September 11, 1997

***RE: LOTS 3A2 -3A9 (G12-D24). GRADING AND DRAINAGE PLAN FOR SITE
DEVELOPMENT PLAN FOR SUBDIVISION AND FINAL PLAT APPROVALS.
ENGINEER'S STAMP DATED AUGUST 12, 1997.***

Based on the information provided on your August 20, 1997 submittal, City Hydrology has the following comments:

GRADING AND DRAINAGE PLAN
LOTS 3A-2 TO 3A-9
ALVARADO GARDENS

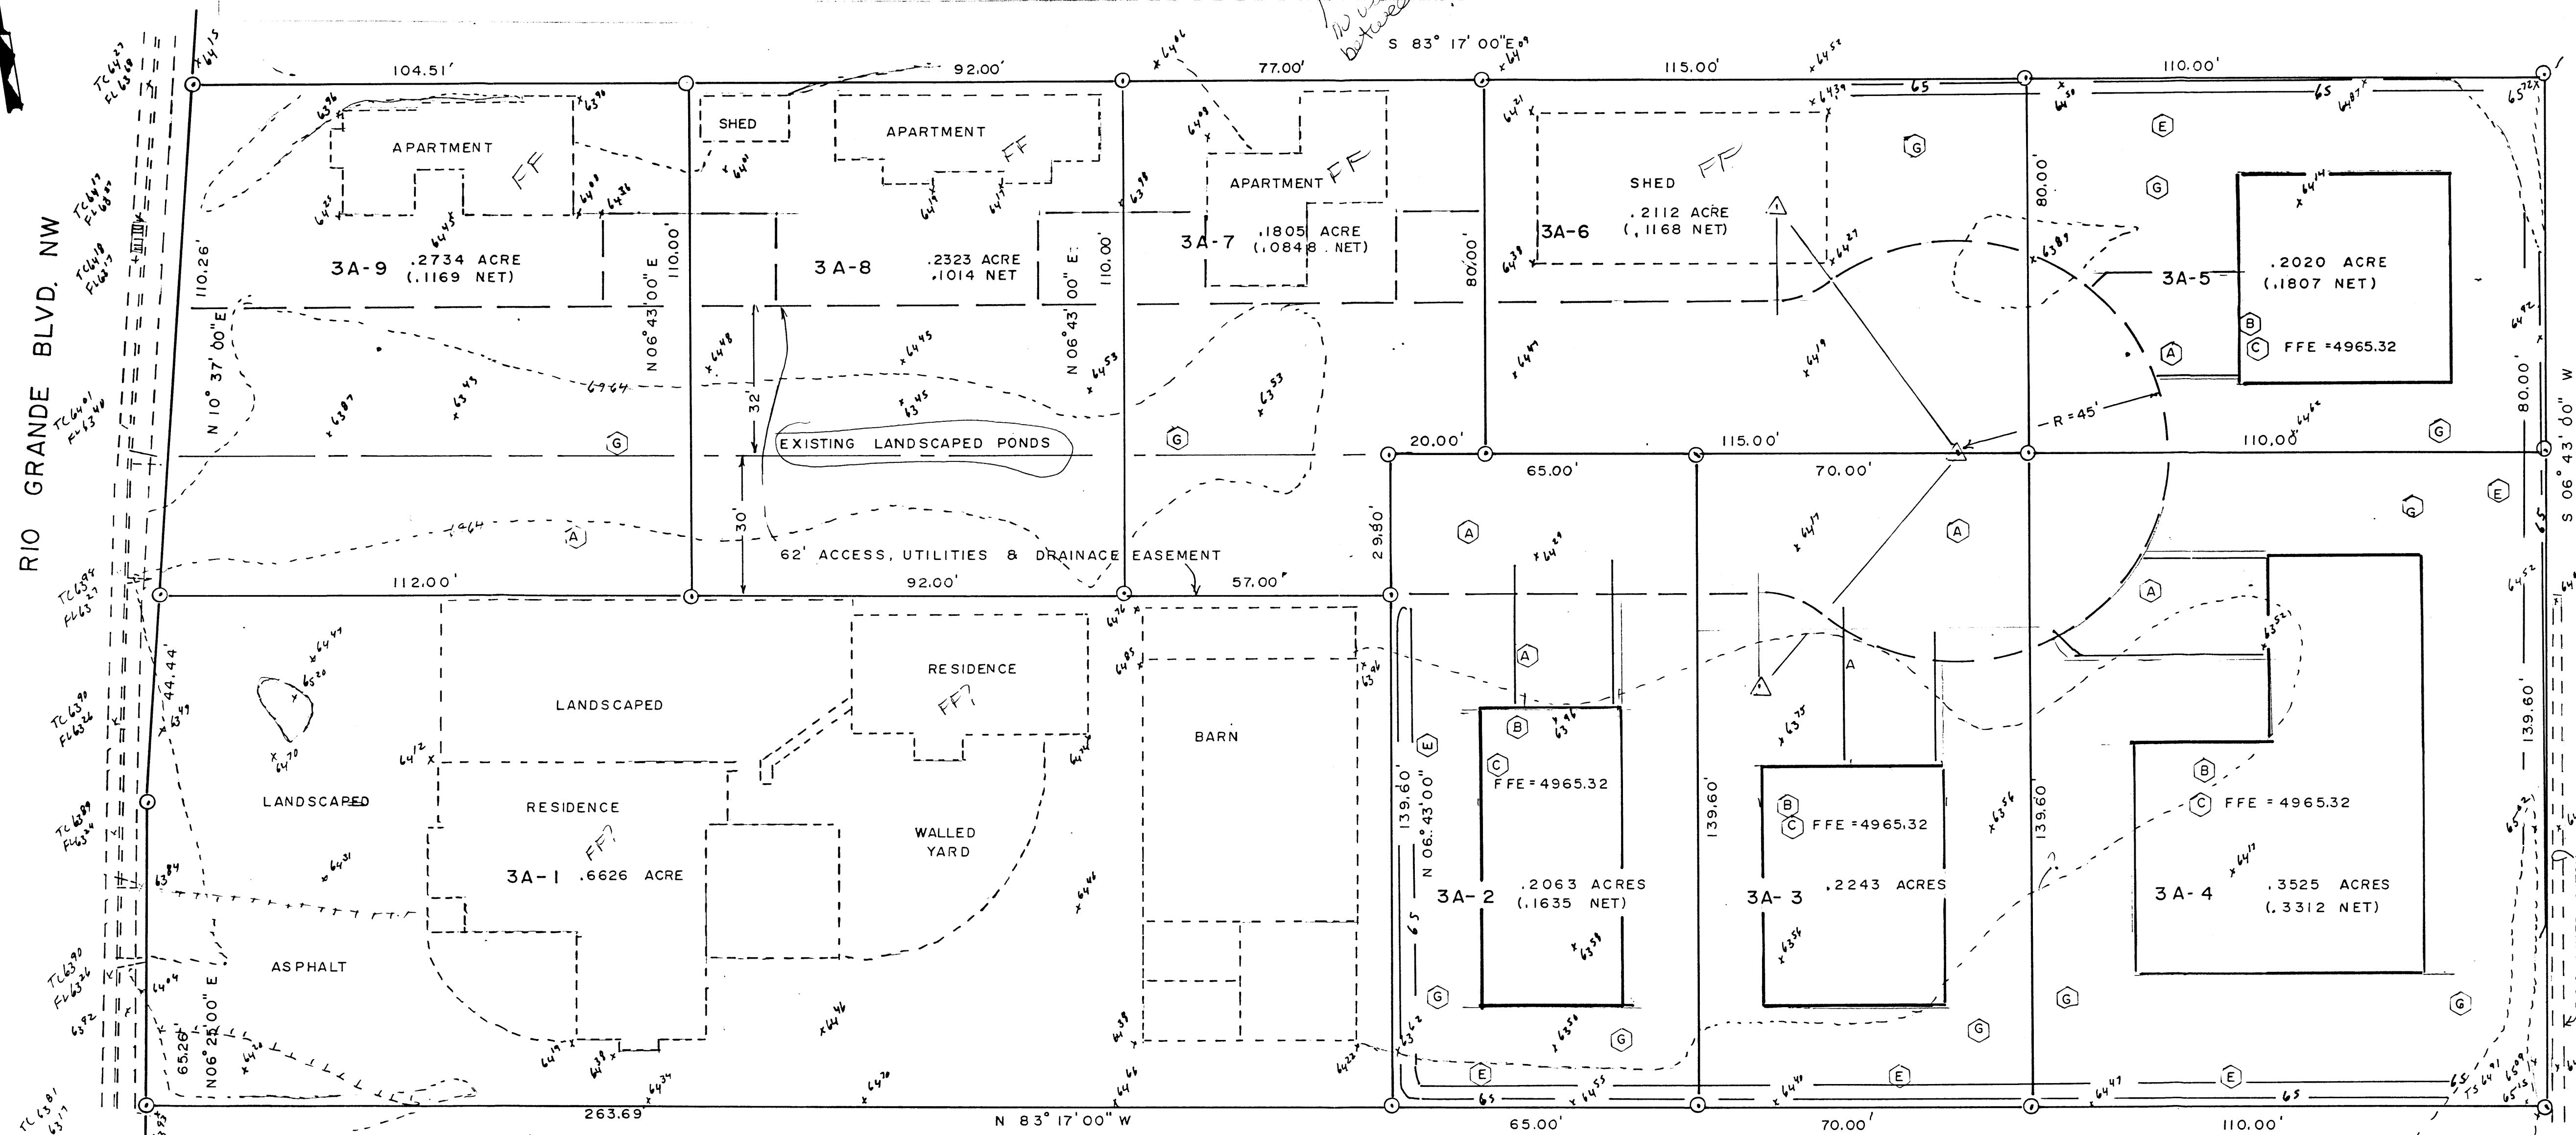
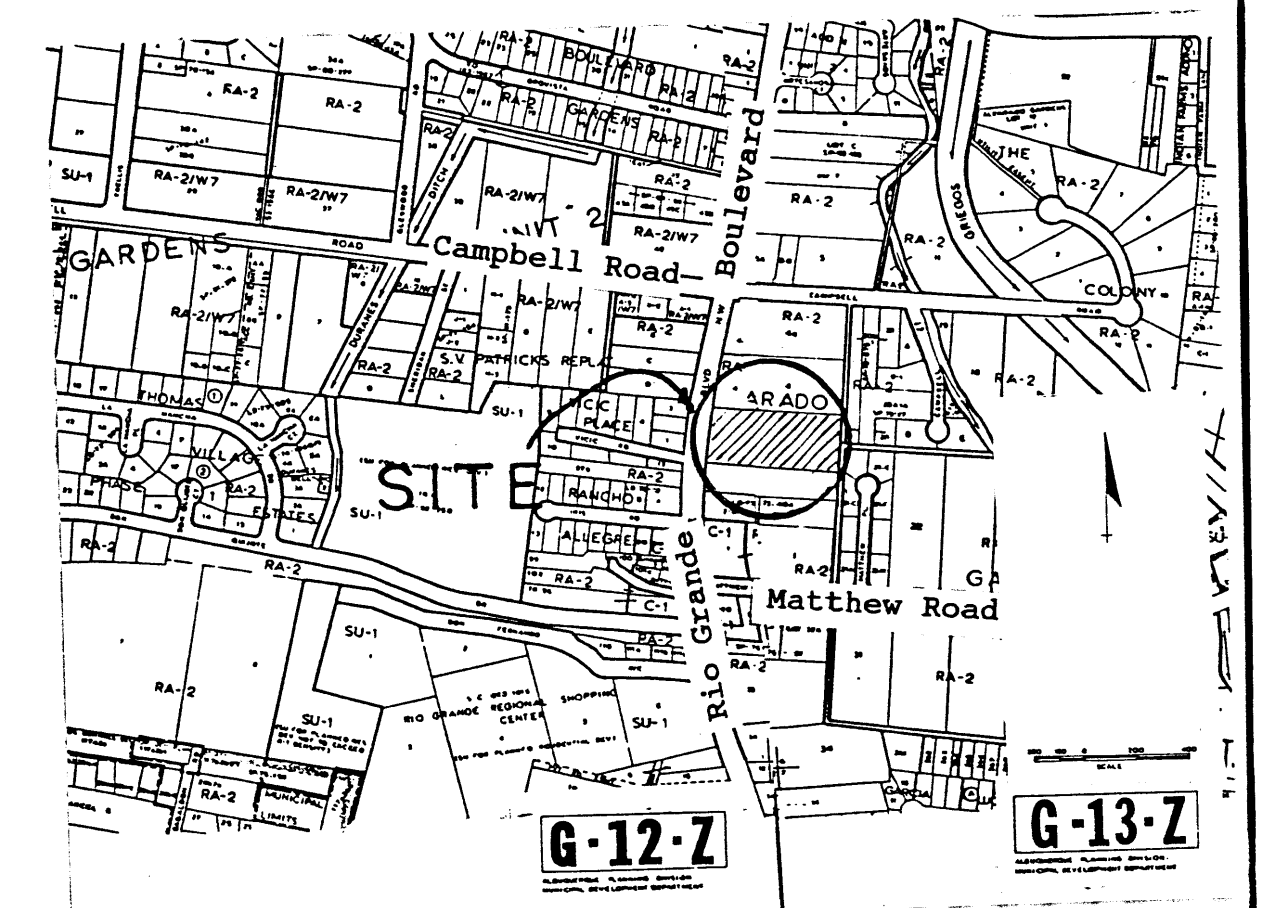
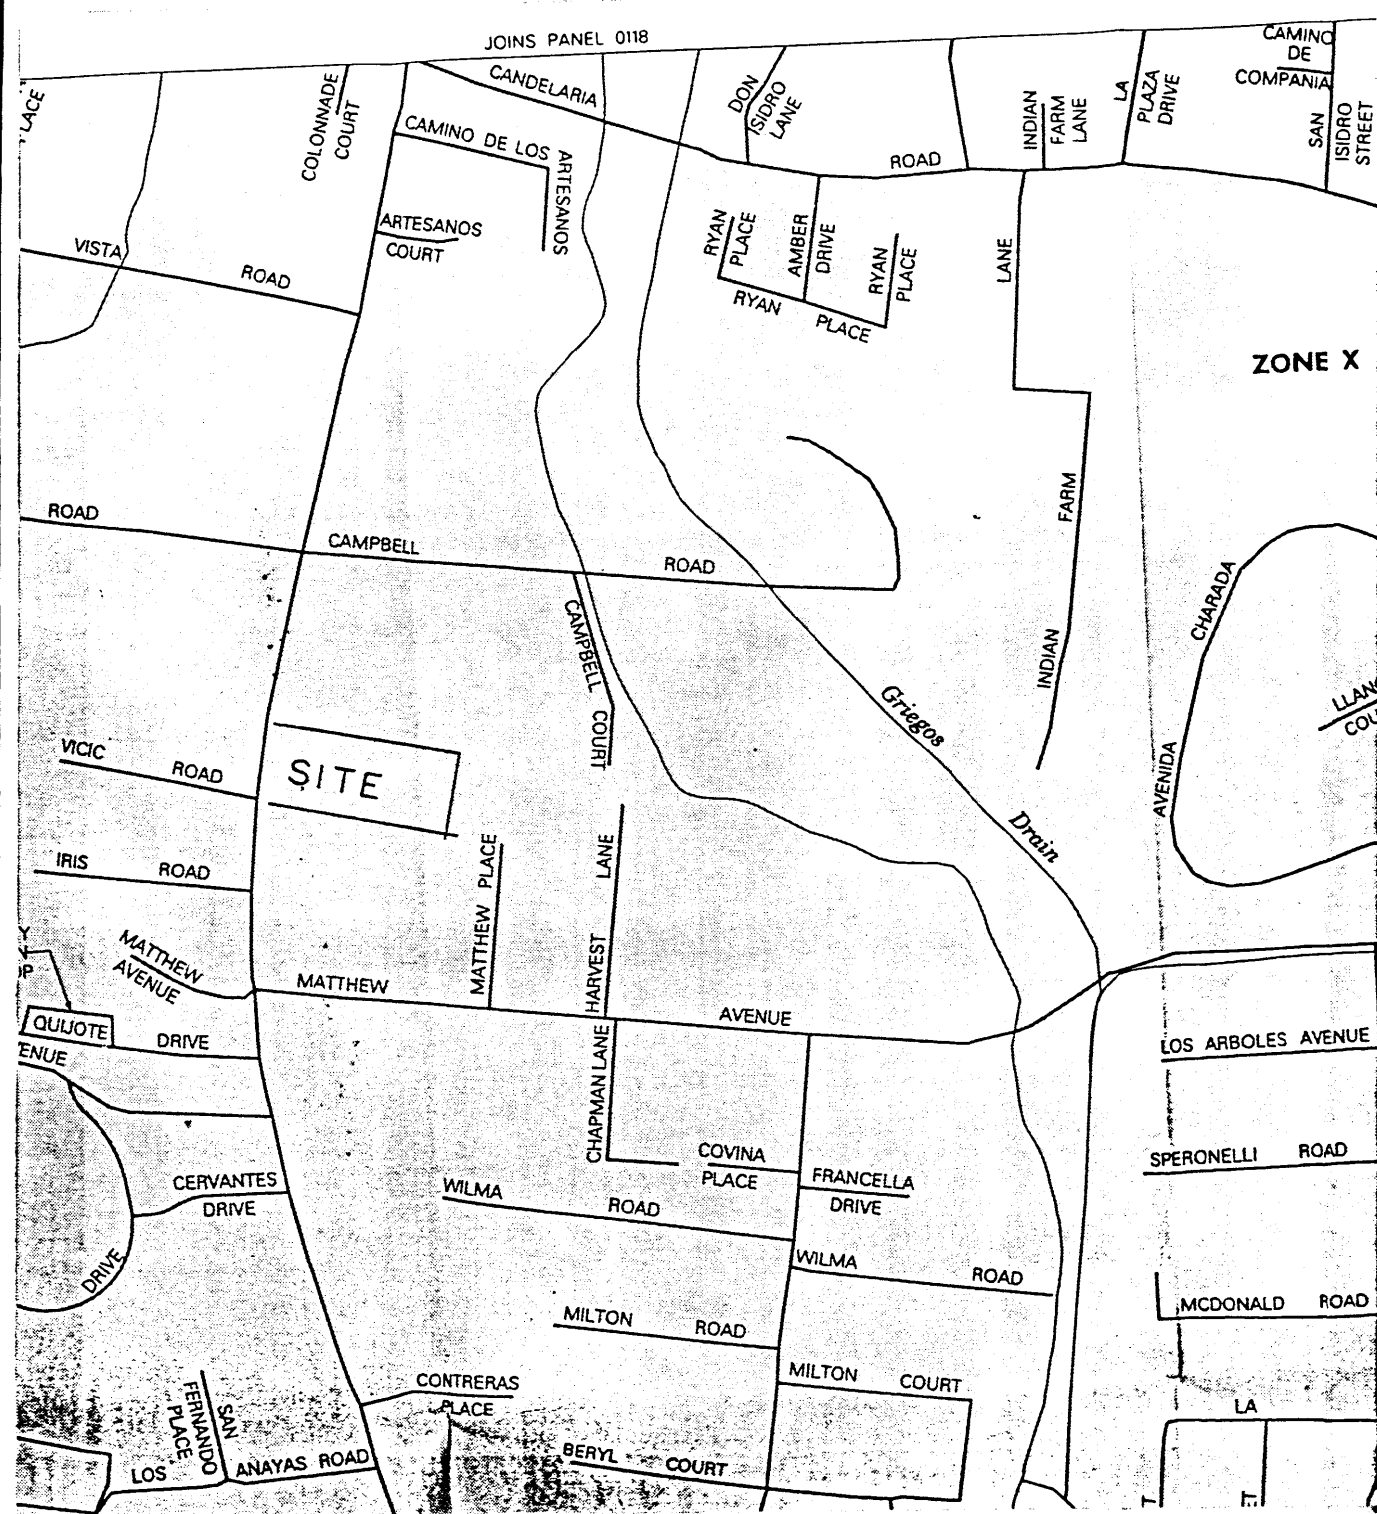
1. Why don't you take some of your storm water to the pipe in Rio Grande? The street is below your site. If you can utilize the storm drain, this site cannot be considered for the flat grading scheme.

2. What is the finish floor elevations for the existing structures? Each structure must have a finish floor elevation of 4965.32 for this site to be considered for a flat grading scheme.

3. Your second page provides basin flow calculations. I am unable to locate these basins on your grading an drainage plan. A flat grading scheme should consist of one drainage basin.

4. A wall will be required along the north, east and south property lines. The flat grading scheme allows for an existing irrigation ditch berm to be used as a perimeter wall, however, the construction of new berms (with no irrigation ditch requirement), in place of walls, is not permitted.

5. Walls will not be permitted between lots. If a barrier is desired for privacy, fences are preferred between the lots. Storm water must be able to flow evenly between lots.

6. Where is the access to these lots? I see the drive way cut along Rio Grande. It looks like there is a landscaped garden or orchard area to the east of the driveway cut. The roadway to these lots must be designed and shown on the plan.
7. A flat grading scheme would require that the entire site have a blanket, cross lot drainage easement. Why do you show a 62-foot drainage easement through the middle of the subdivision?
